Appendix I to the Relevant Representations of Natural England
Seascape Landscape and Visual

The construction and operation of the Five Estuaries Offshore Wind Farm located approximately 37km from the Suffolk Coast in the Southern North Sea.

Planning Inspectorate Reference EN010115

13 August 2024

This image provides landscape and visual context only

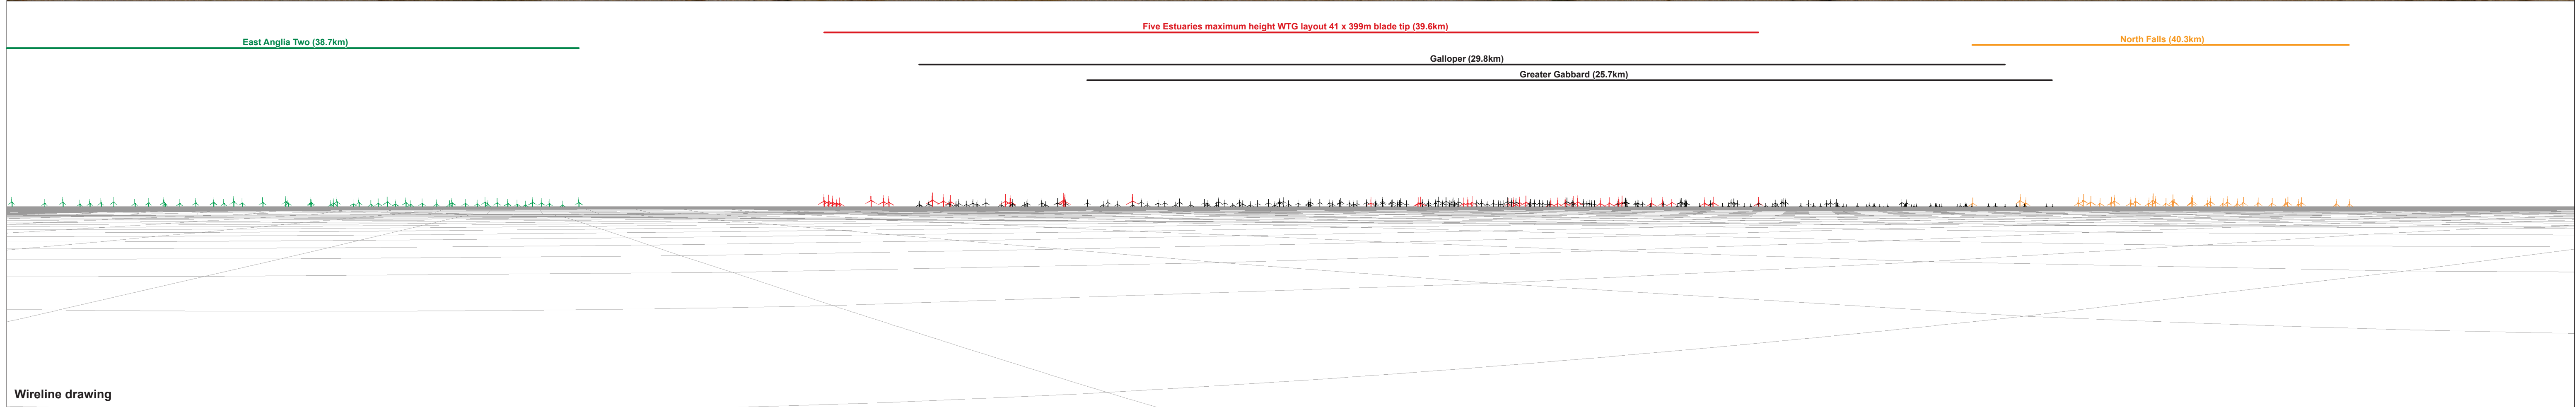
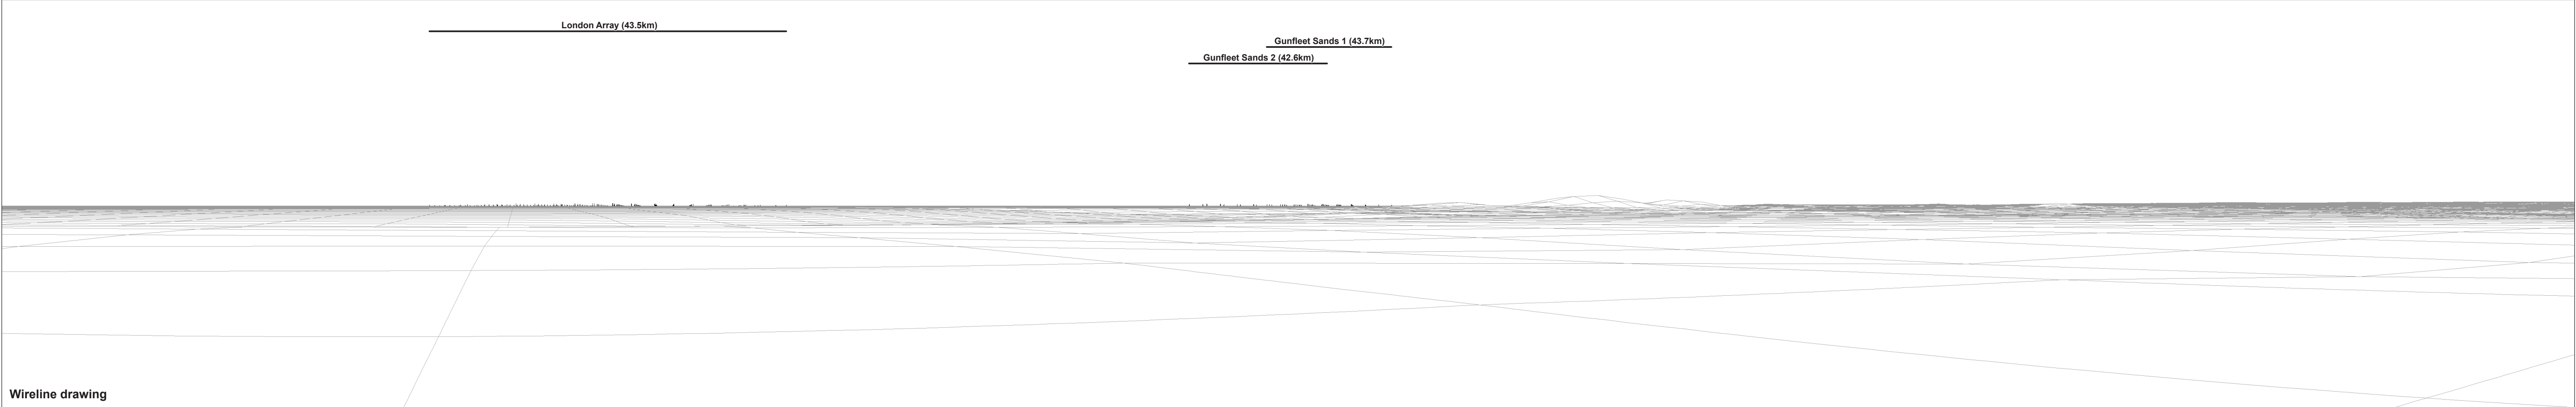
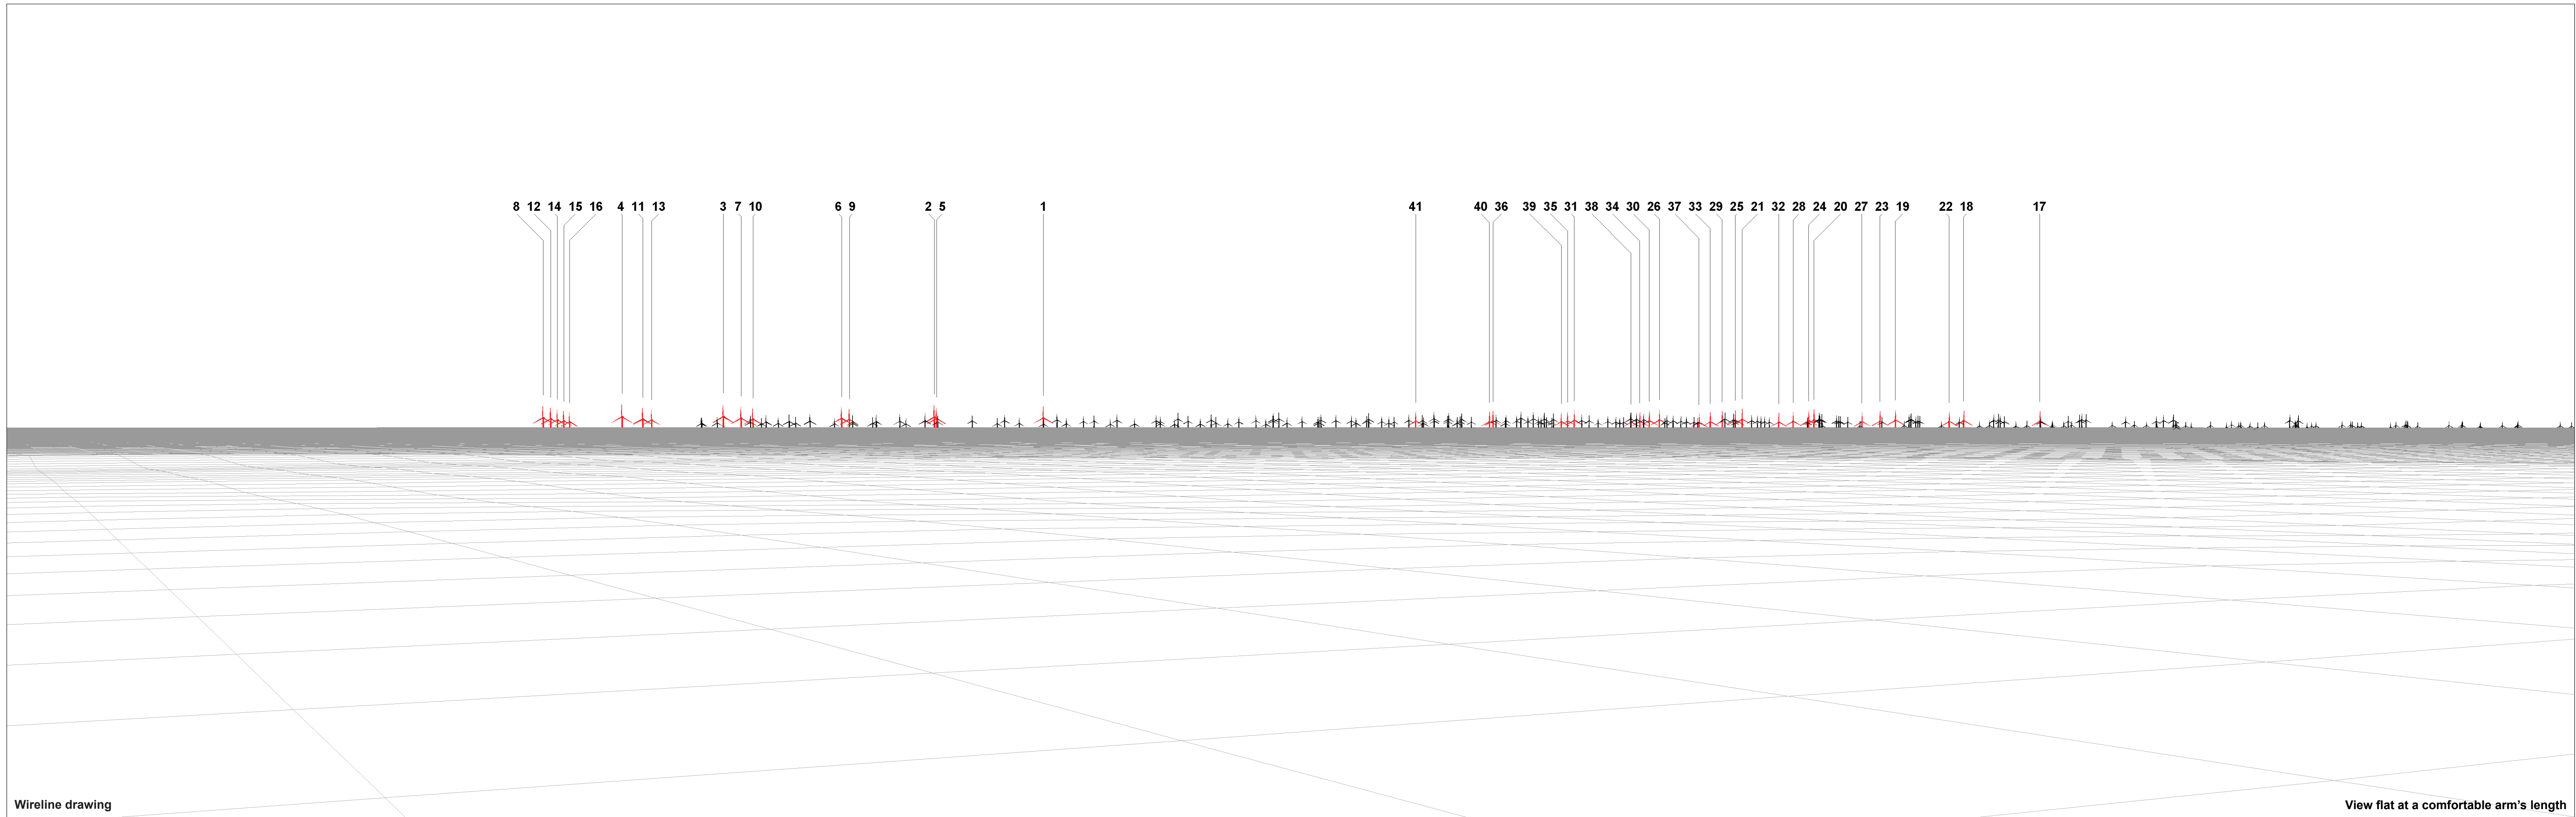
1.7 In particular, we draw the Examiners' attention to the value for the viewpoint located on **Orford Ness**, which should be considered in the context of the highly sensitive nature of this location, principally in terms of potential for significant adverse effects to the SCHAONB wildness and tranquillity special qualities.
